Tuck O'Brien
City Planning Director, Planning Division

Project Name: **India Newbury Residences** Project ID: 2016-052
Address: 62 India Street CBL: 028 P008, P009, P015, P019, P020
Applicant: India Newbury Residences, LLC
Planner: Caitlin Cameron

TO: Caitlin Cameron, Planner
FROM: Lauren Swett, PE
DATE: May 16, 2016
RE: 62 India Street, Site Plan Application – Response to Comments

Re: Final Review Comments for 62 India Street – India Newbury Residences,
LLC (2016-052)

Residential Area
Reduction (May 20, 2016)
REVISED TOTAL AREA

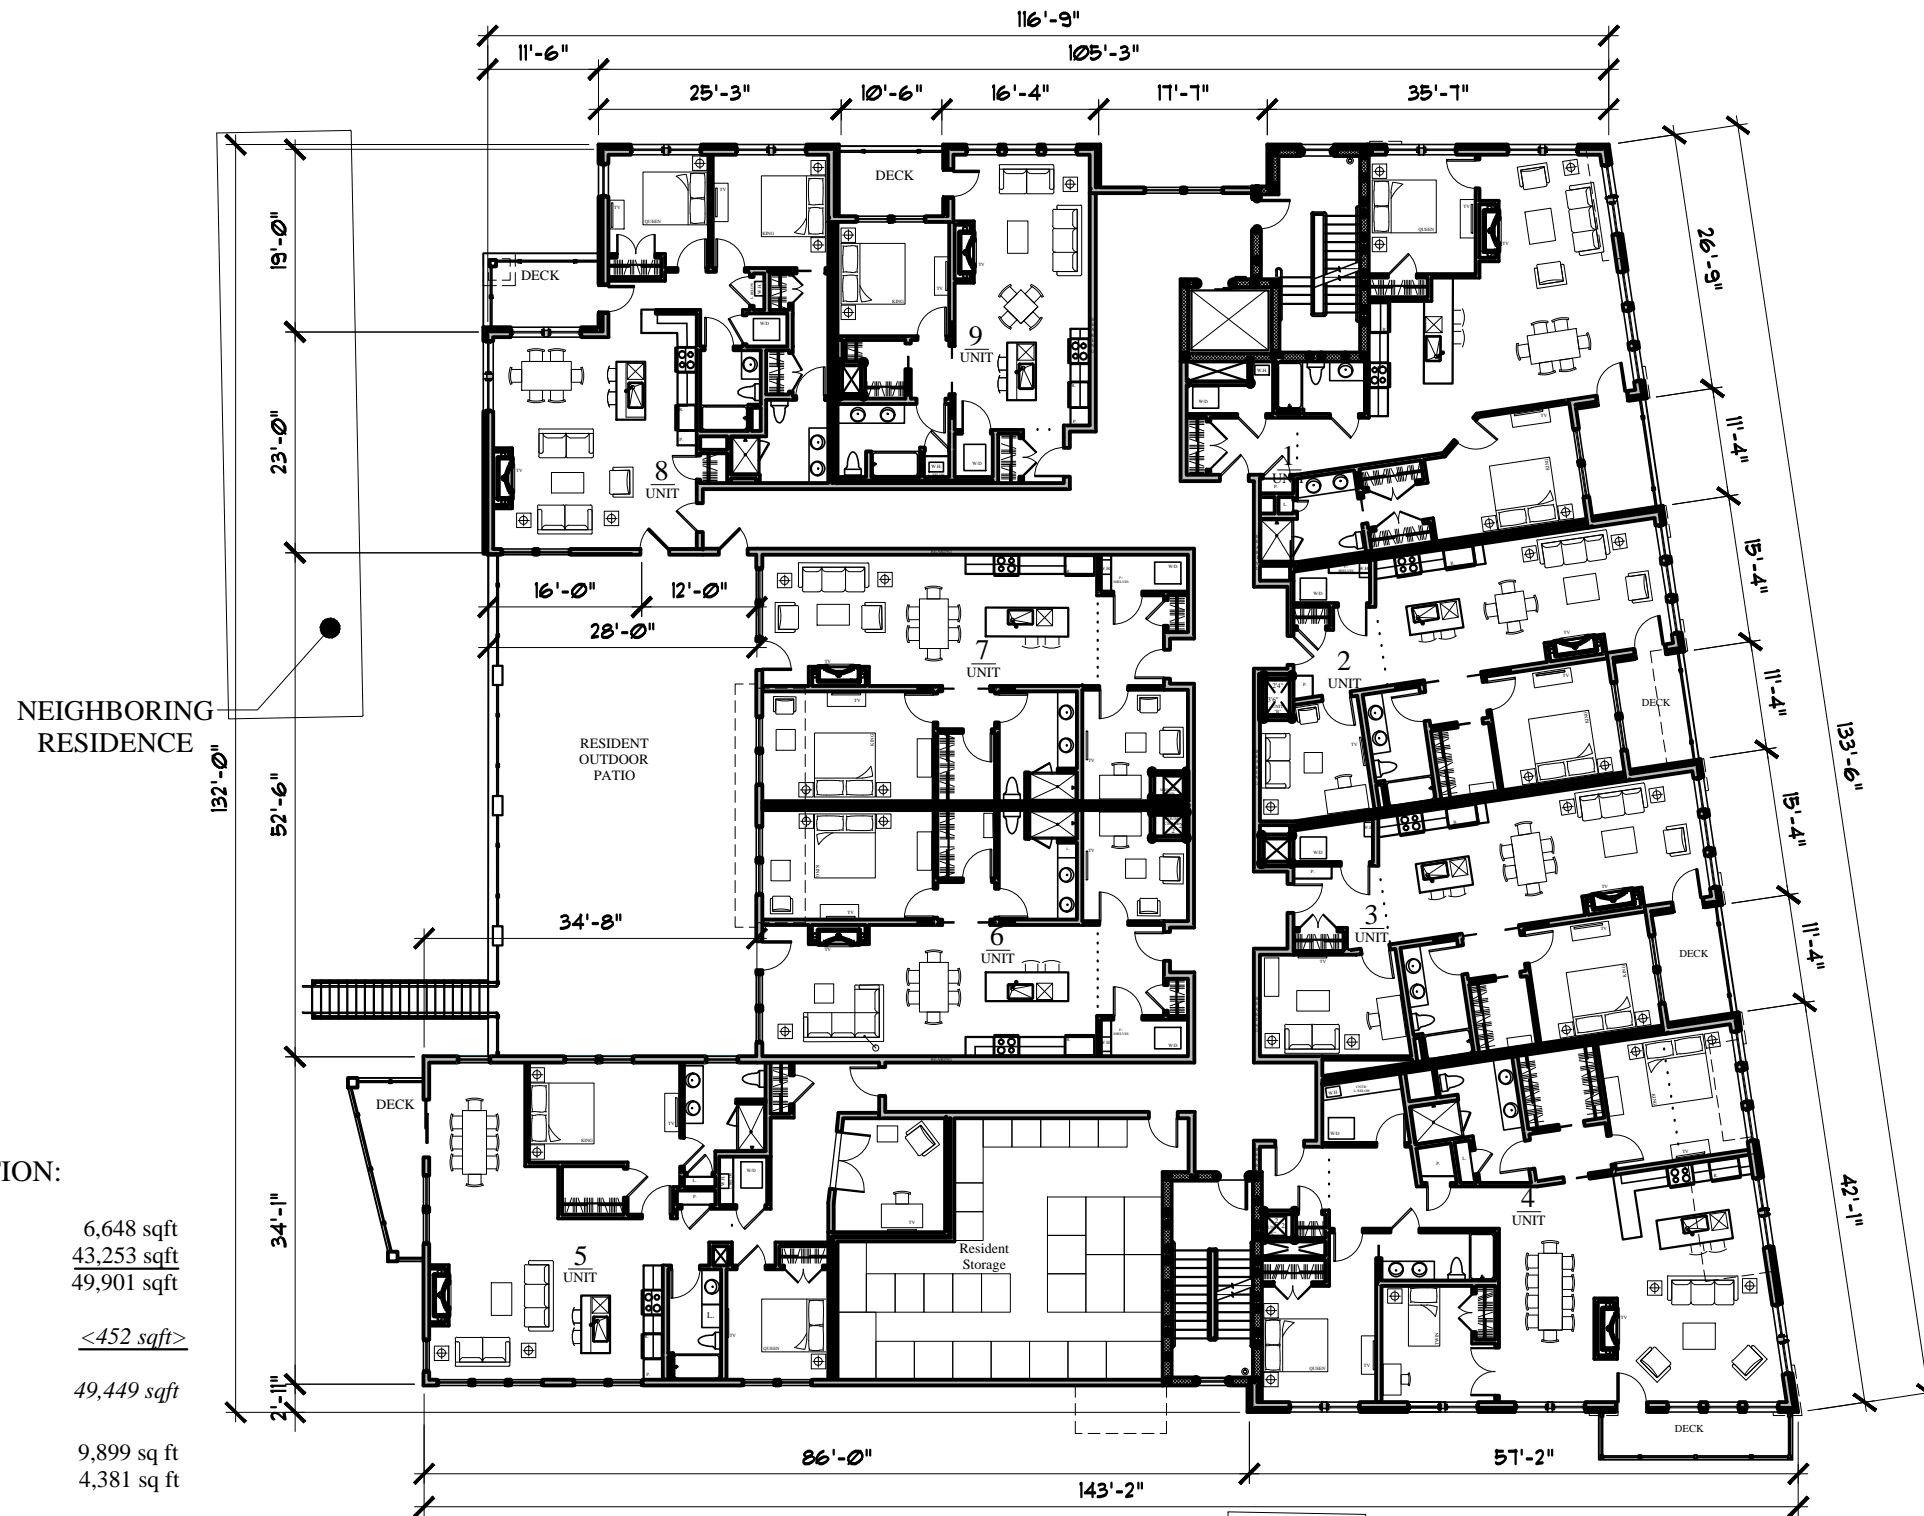
1. The final design of the sidewalk including cross slope, curb extension, and street tree well shall be revised and submitted to staff for final approval.
2. The applicant shall provide revised drawings showing correct area calculations.

EXISTING CONDITIONS PLAN
 OF:
 50-62 INDIA STREET
 PORTLAND, MAINE
 FOR:
 INDIA NEWBURY RESIDENCES, LLC
 35 ST. STE. 1078
 PORTLAND, ME 04108

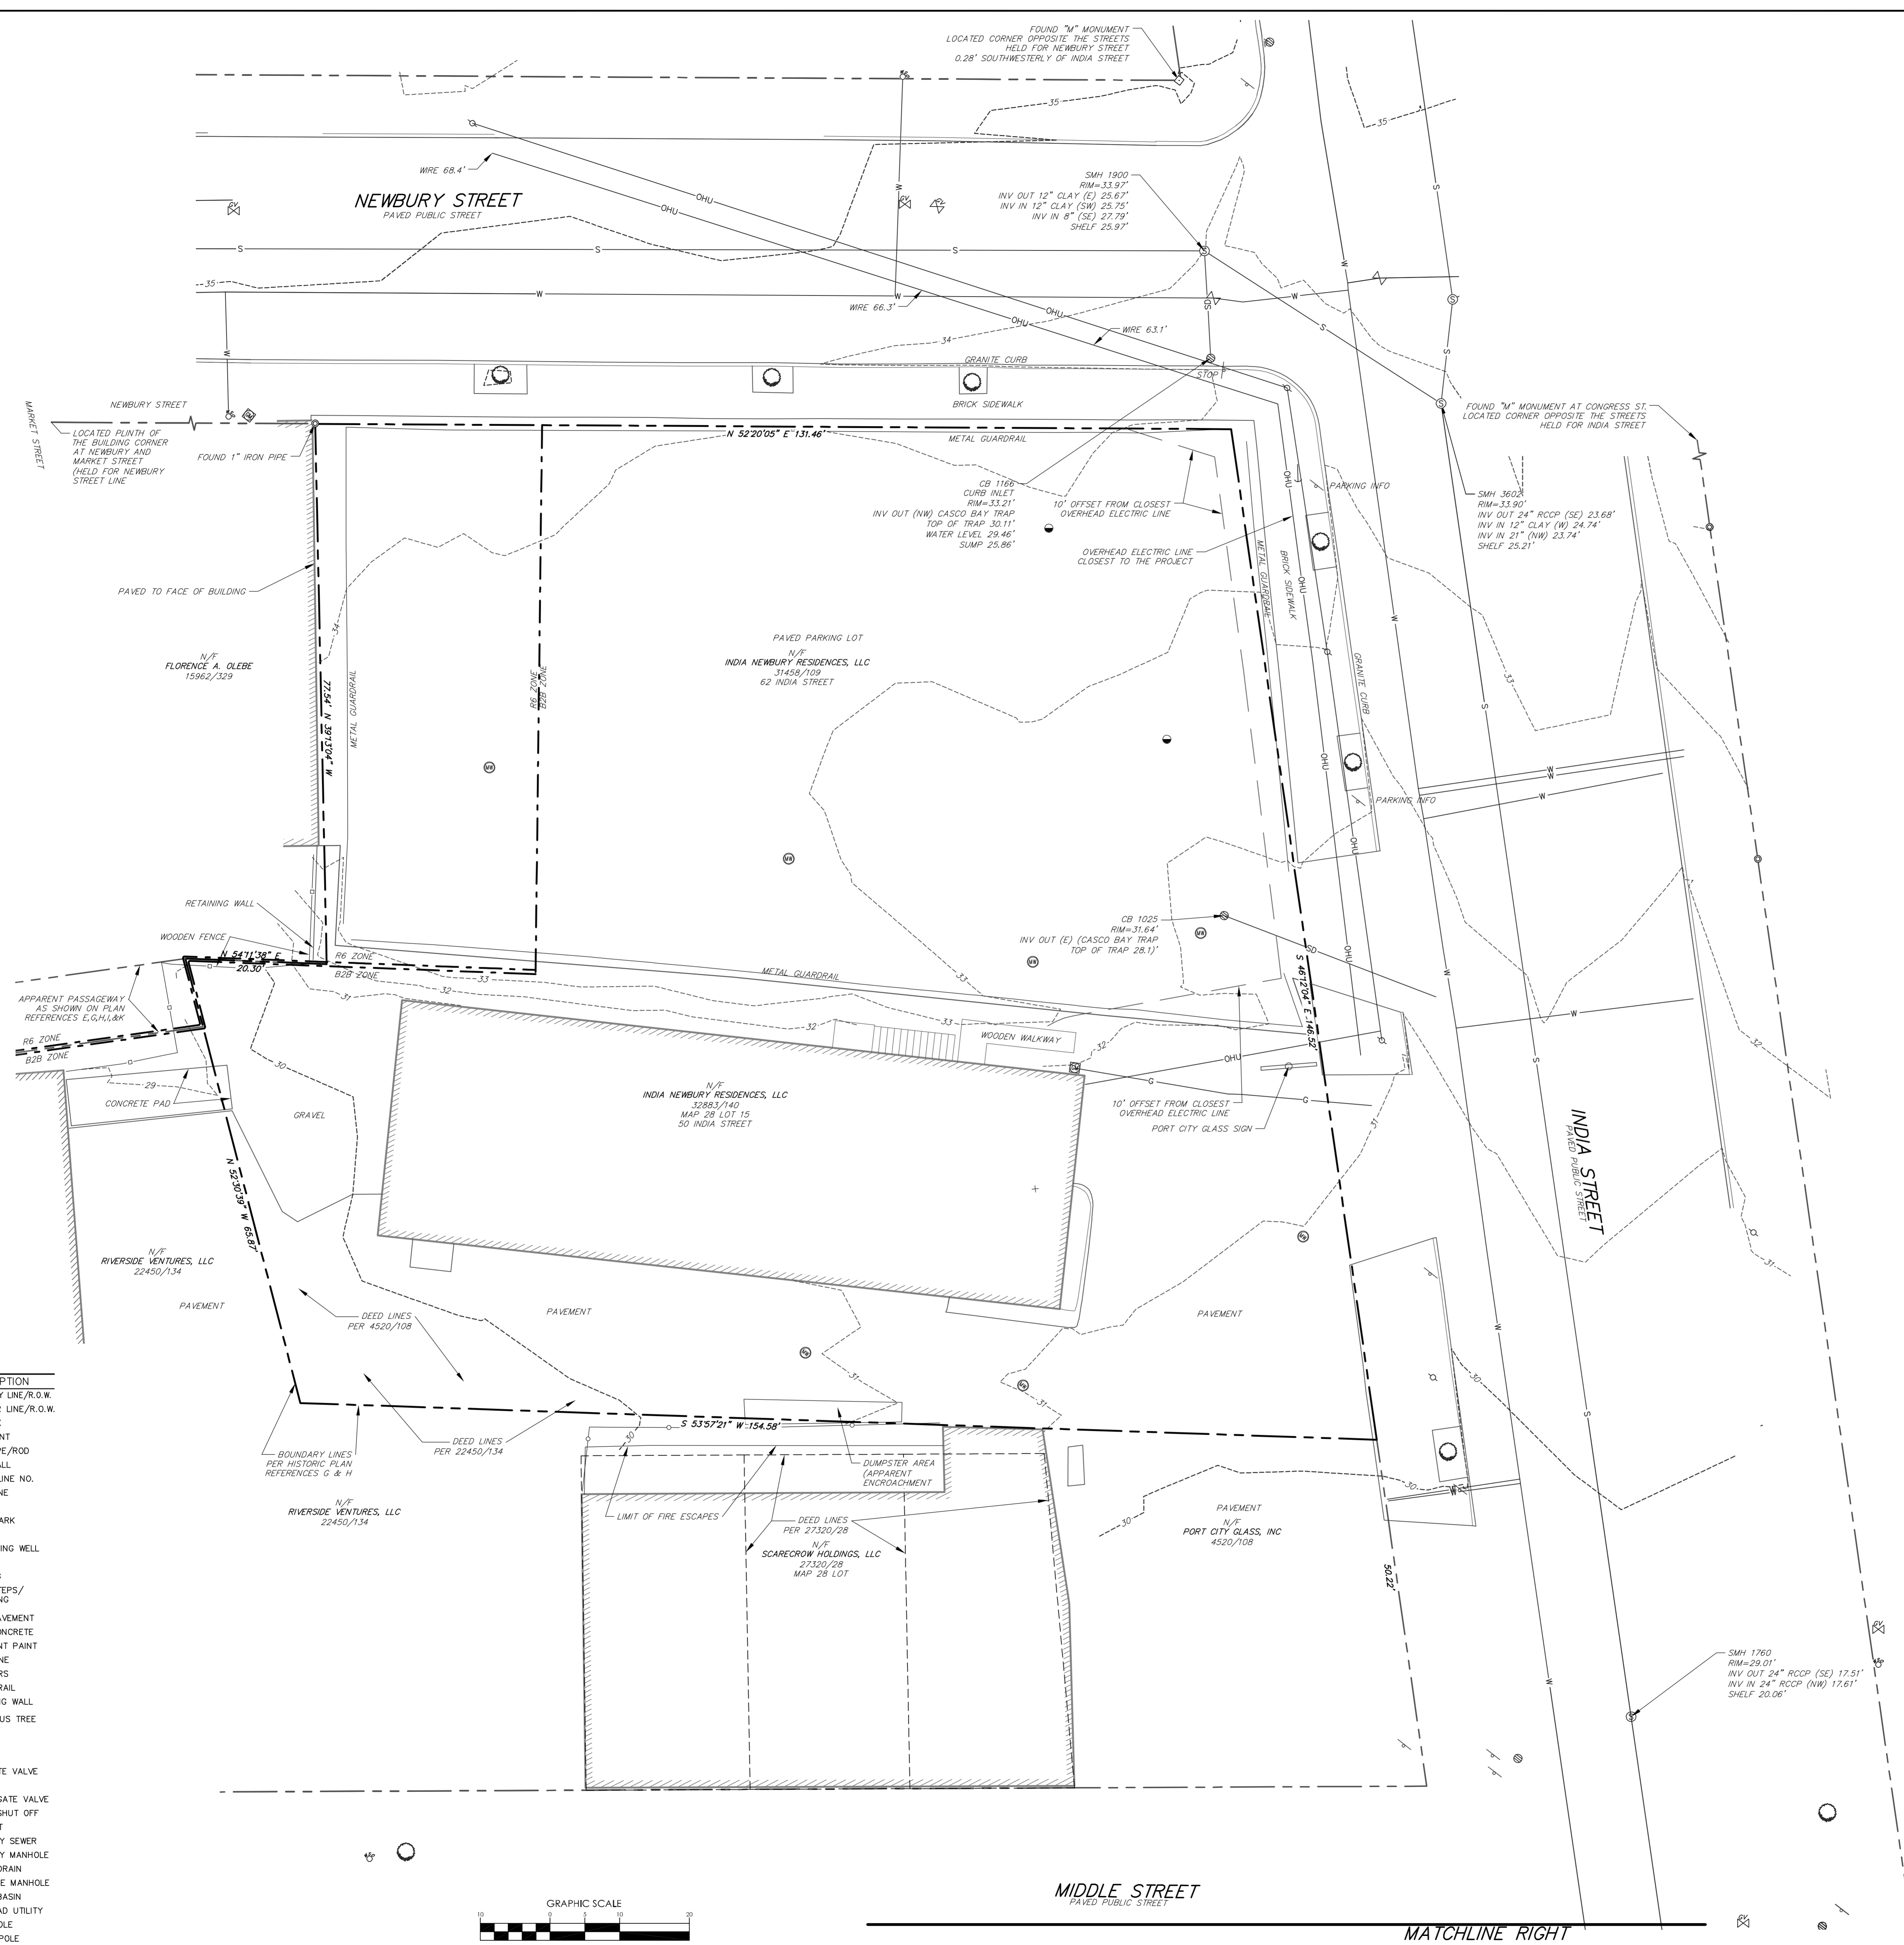
“The proposed three foot offset monument center needs to be at the intersection of the three foot offset lines; on the plan the corner of the monument is shown at the intersection of the three foot offset lines.”
